TO: CHAIR AND MEMBERS OF THE ZONING BOARD OF APPEALS
FROM: ANN MACHADO, ZONING SPECIALIST *AM*
SUBJECT: 5 BRAMBLEWOOD DRIVE, 377 E006 - R-3 RESIDENTIAL ZONE
DATE: NOVEMBER 29, 2012

Re: 5 Bramblewood Drive – 377 E006 – R-3 Residential Zone – Permit #2012-10-5099
–daycare as home occupation

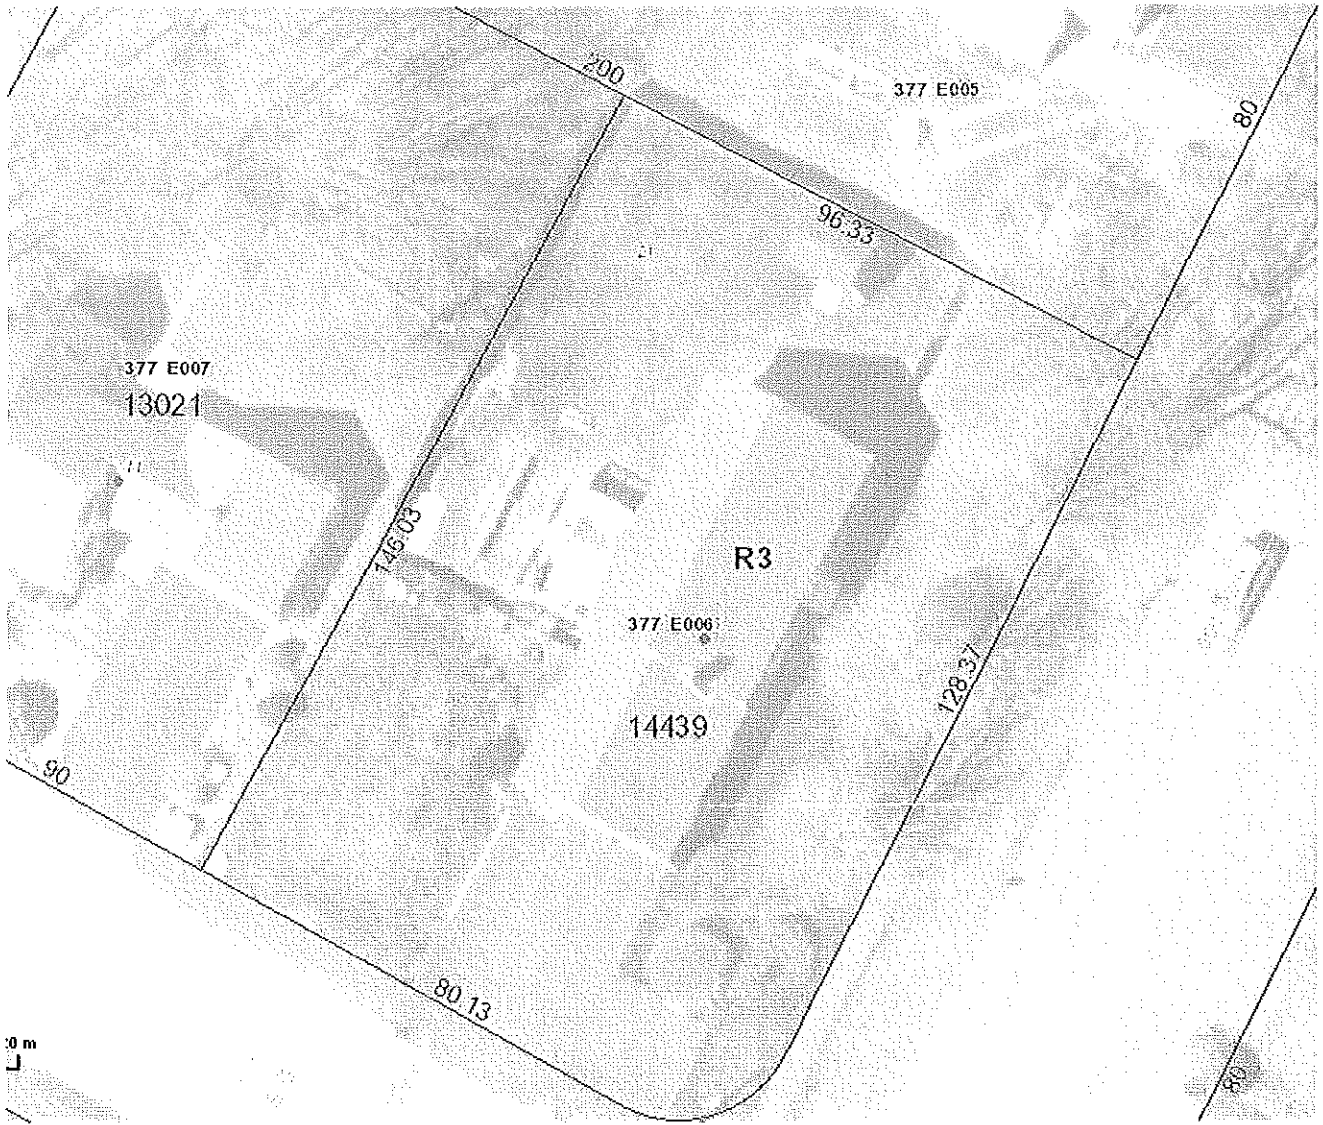
I wrote a letter on October 11, 2012 explaining why the second kitchen needed to be removed. Section 14-47 of the ordinance defines a dwelling unit as "one (1) or more rooms with private bath and kitchen facilities comprising an independent self-contained unit". The floor plans show that the lower level has a living room, dining area, bedroom, kitchen facilities and a private bath. The property is located in the R-3 residential zone. Section 14-86 states that the purpose of the zone is "to provide for medium-density residential development characterized by single family homes on individual lots". When a second kitchen is added to a single family home, by definition a second unit is created. By having one kitchen in a building it guarantees that the use will remain a single family home and not allow for an illegal dwelling unit to be created. There is a process to allow an accessory dwelling unit as a conditional use appeal.

In reviewing your application to add a daycare as a home occupation, I noticed on your floor plans that there are two kitchens in the home, one on the main floor and one on the lower level. Our records show the legal use of the property as a single family home or a single dwelling unit. Section 14-47 defines a dwelling unit as “one (1) or more rooms with private bath and kitchen facilities comprising an independent self-contained dwelling unit”. In other words a dwelling unit has one kitchen. A second kitchen in a building changes the use of the building from one dwelling unit to two dwelling units. I have researched our records, and there is no record of a second kitchen being added to the building. Since the use of the building is one dwelling unit, the second kitchen is illegal and needs to be removed.

ordinance defines kitchen facilities as “facilities used for the preparation of meals, including refrigerators and devices used for the cooking and preparation of food”. In one of our telephone conversations you said that there was a full sized refrigerator and a stove in the lower level. These would have to be removed along with any sink and other device used for cooking and preparation of food.
